EXHIBIT “G”

June 6, 2023

Subject: **Review of Revised Plans**
Proposed New Residence
6950 Southeast Maker Street
Mercer Island, Washington

SECTION SH1 1
SCALE: 1/4" = 1'-0"

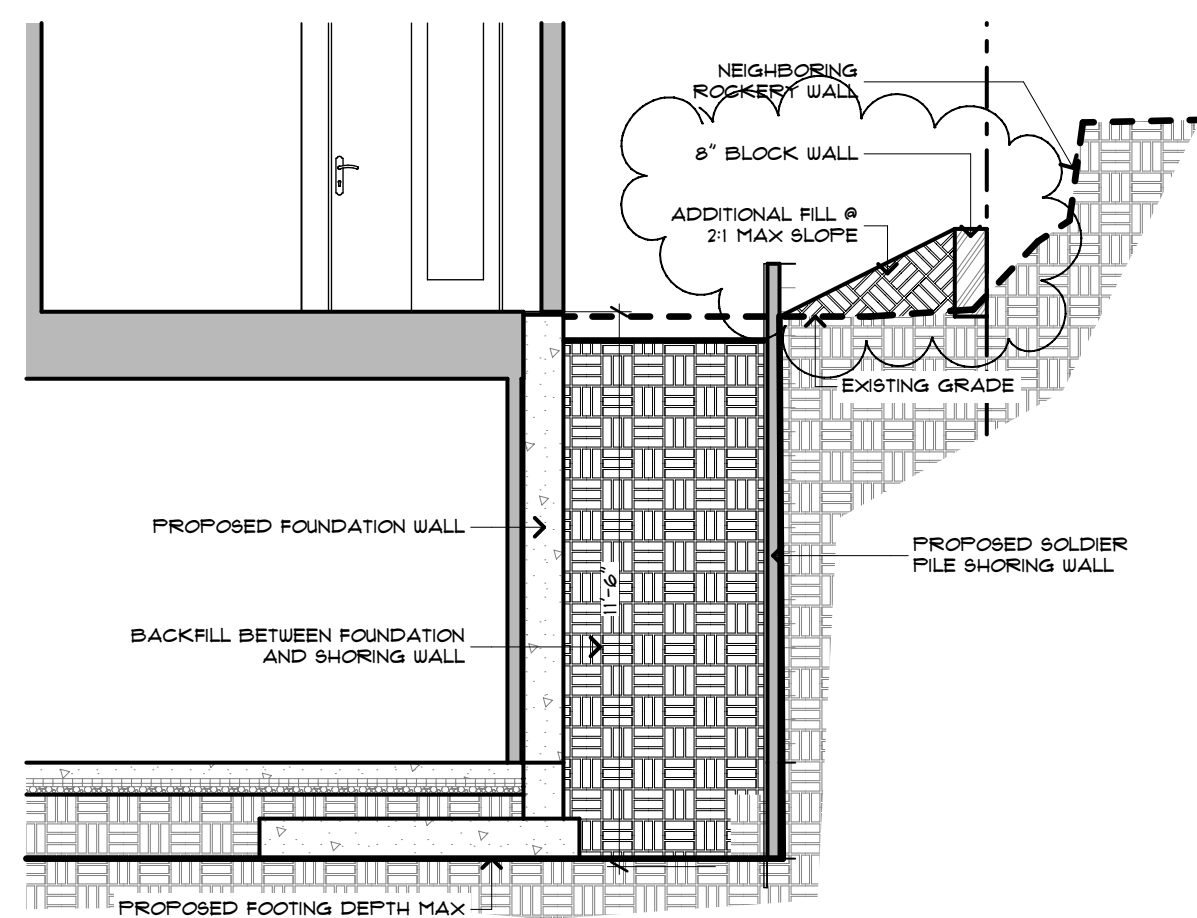
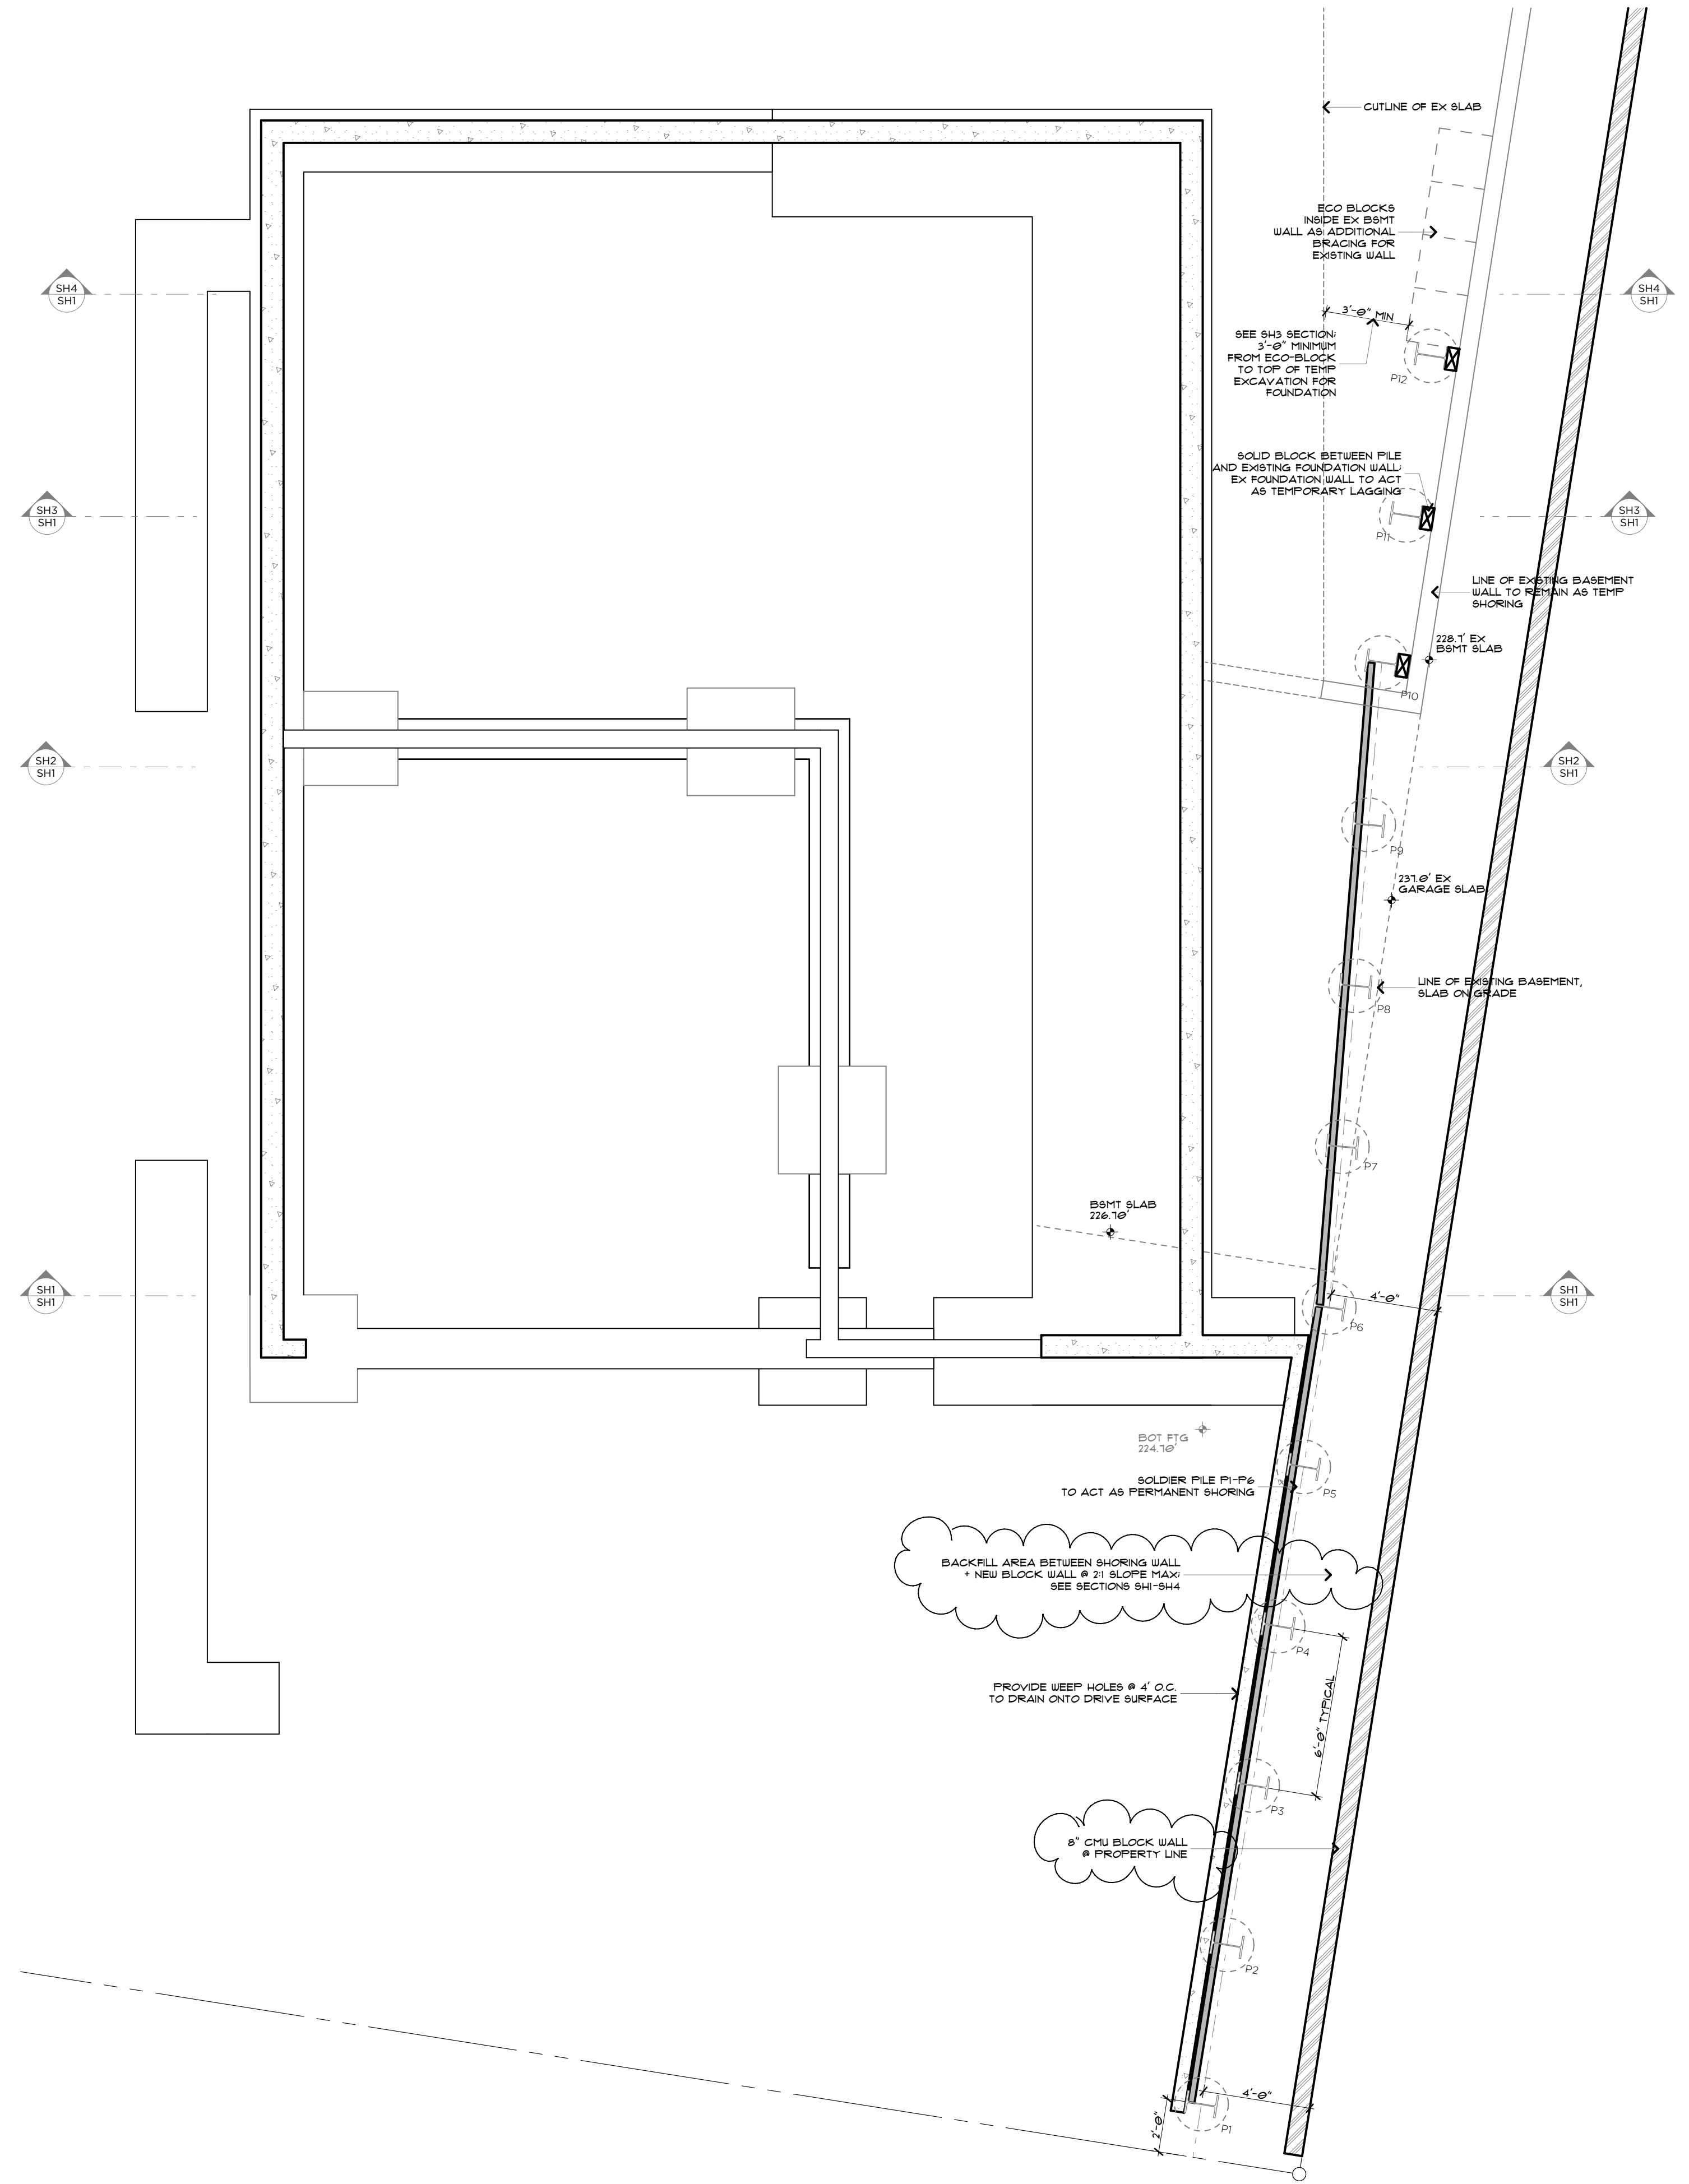
The shoring (SH) drawings correctly depict the partial removal of the existing western rockery, combined with the installation of closely-spaced soldier piles immediately behind the remaining lower portion of the rockery. The remaining lower approximately 5 feet of the rockery will no longer have to resist any lateral soil load, as this will be accomplished by the stabilization piles. This

The Site Plan and sections on SH1, as well as sheets C-2 and C-3, properly illustrate the fill berm and modular block wall to be constructed as protection against a potential failure of the eastern neighbor's modular block wall.
